Luminato green roof specifications

David Senus <dsenus@woodardcurran.com>

Thu, Mar 17, 2016 at 5:19 PM

Date: **AUG. 5, 2016**
 Scale: **3/16" = 1'-0"**
ROOF PLAN

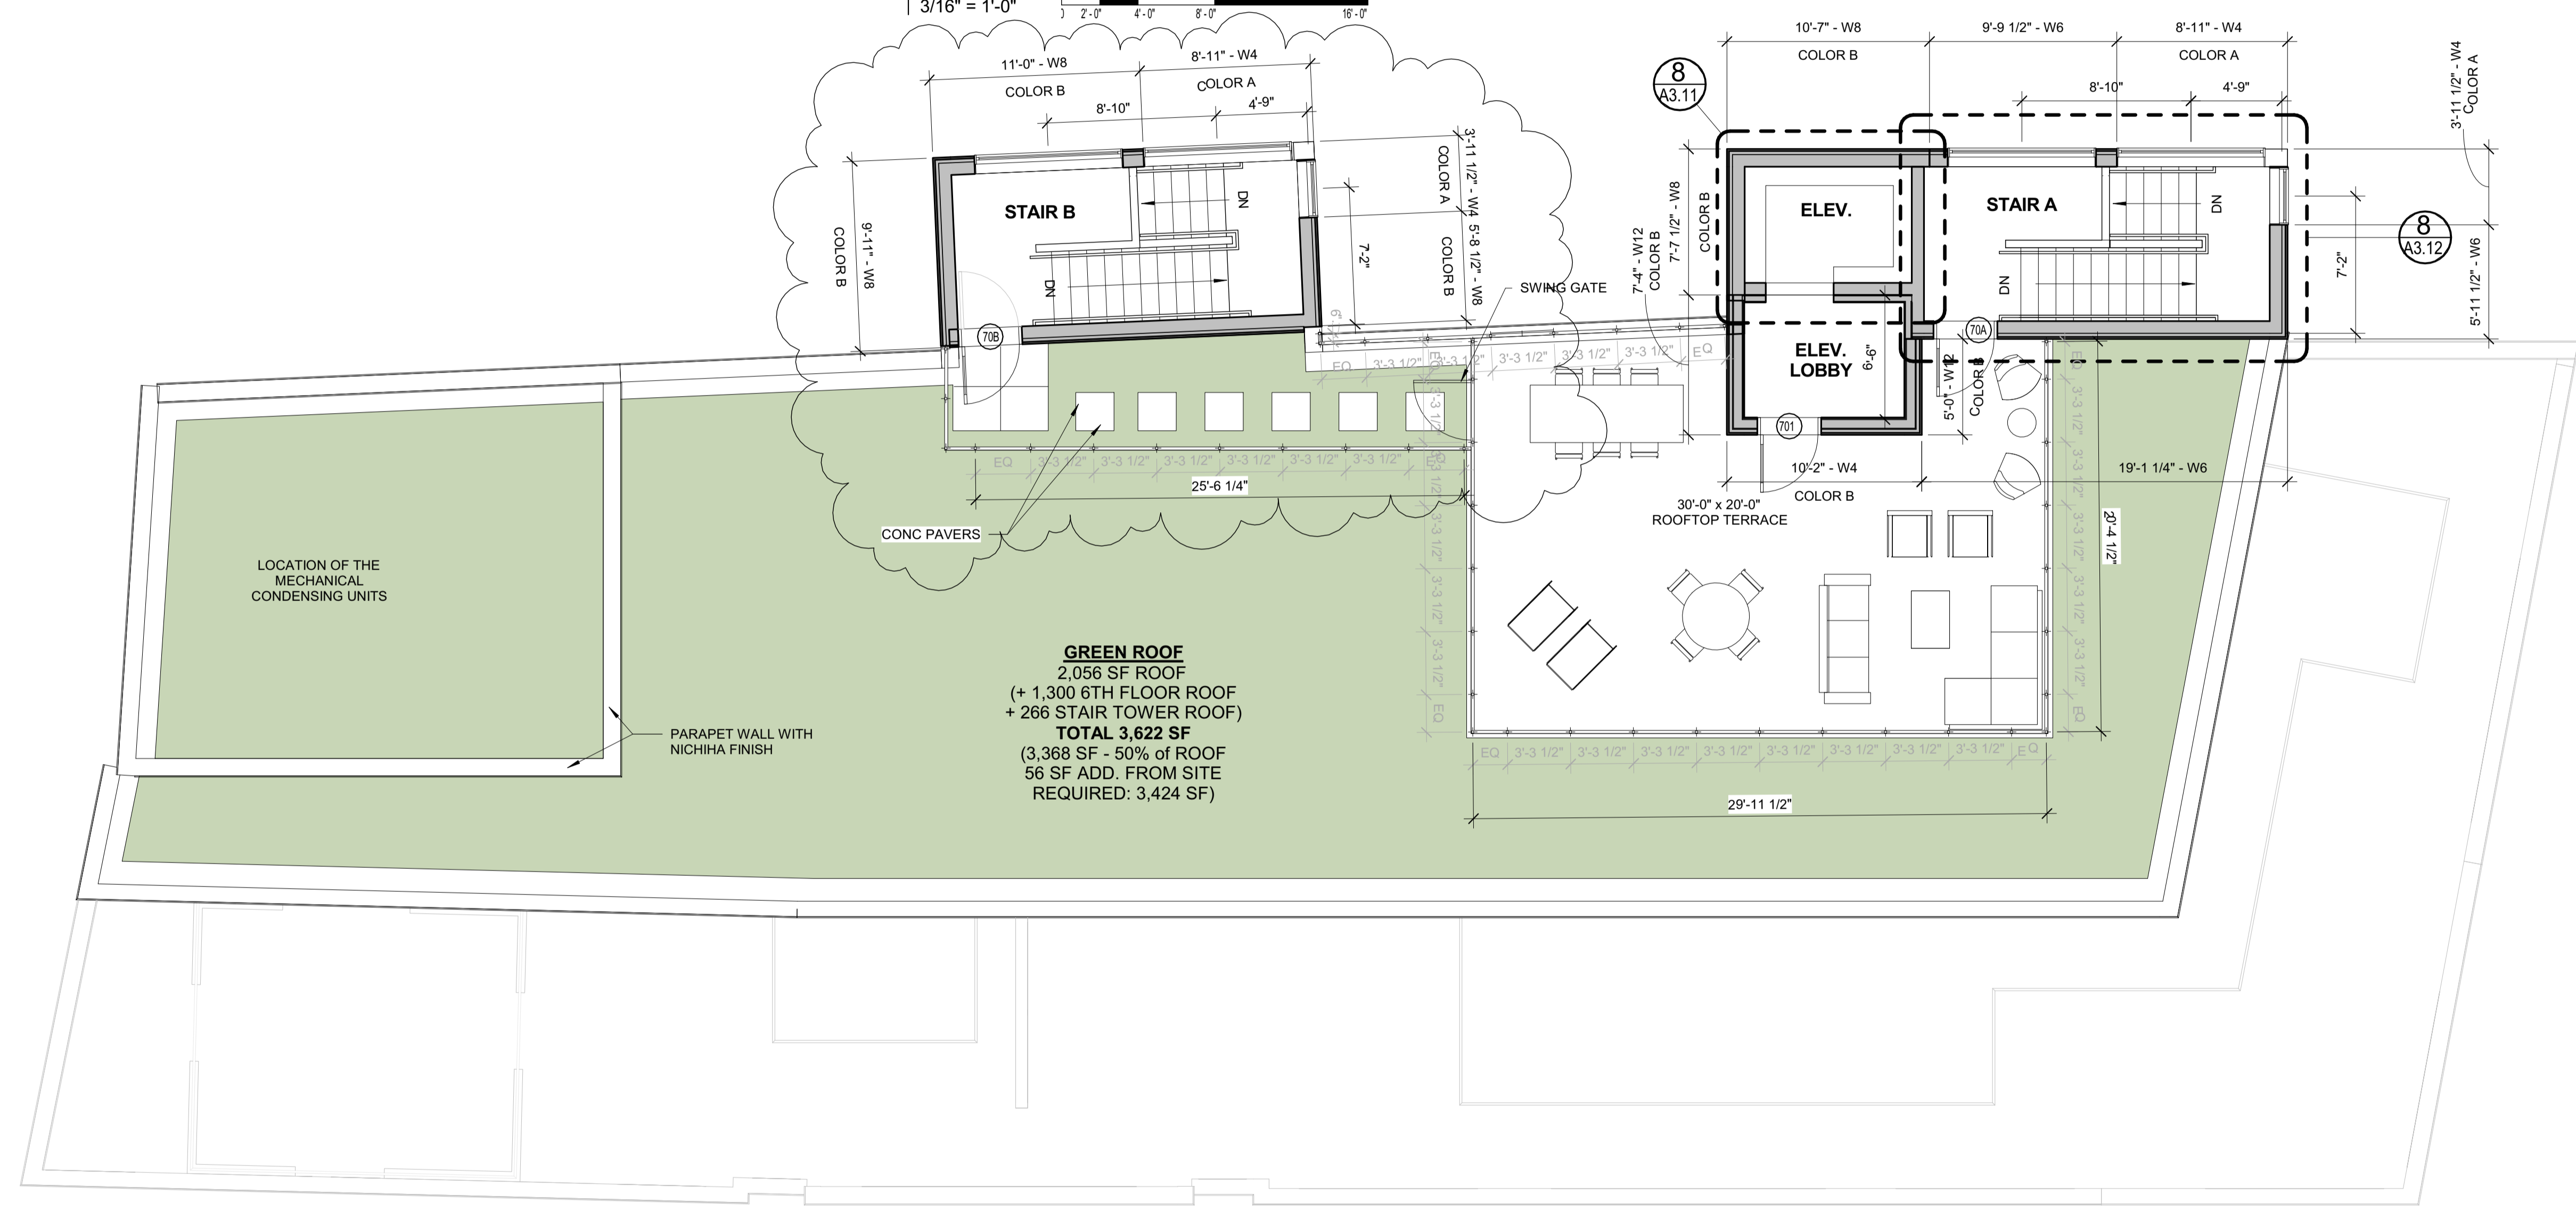
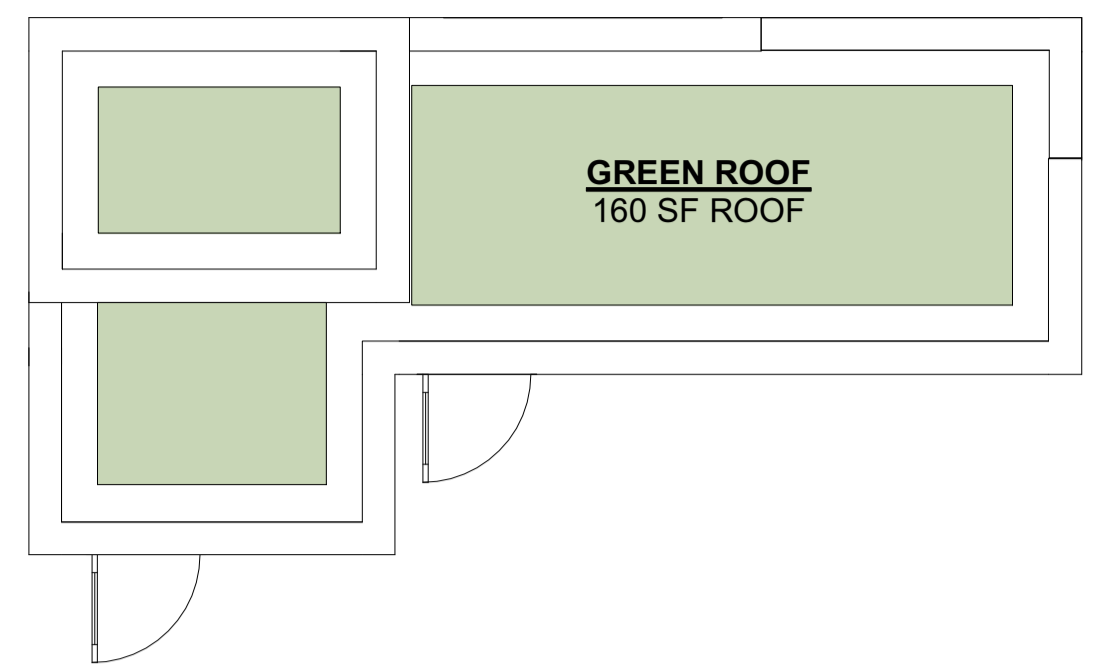
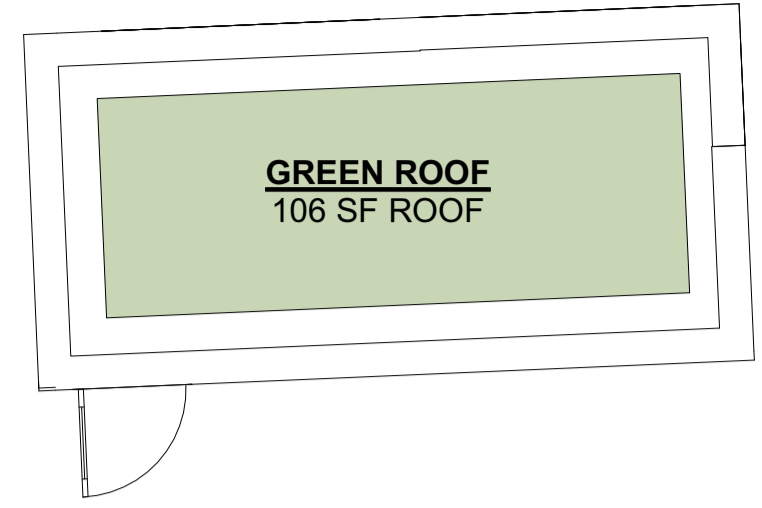
The maintenance info contained in the submitted specification is only a 2 year maintenance service requirement for the contractor; it wouldn't meet the requirements of Chapter 32 and would offer no assurance that the green roof is being maintained after 2 years.

If the task at hand is to determine whether the green roof is "designed to meet the Maine Stormwater Best Management Practices Manual standard and Recommendations" per the green roof definition in the land use code, the applicant will need to supply design drawings and calculations. Our initial request in mid-February was as follows;

"Green Roof System – Provide plans/details for the green roof system, and a report that includes calculations and an evaluation of how the green roof will provide water quality treatment and how the system will reduce flowrate into the City's combined sewer system"
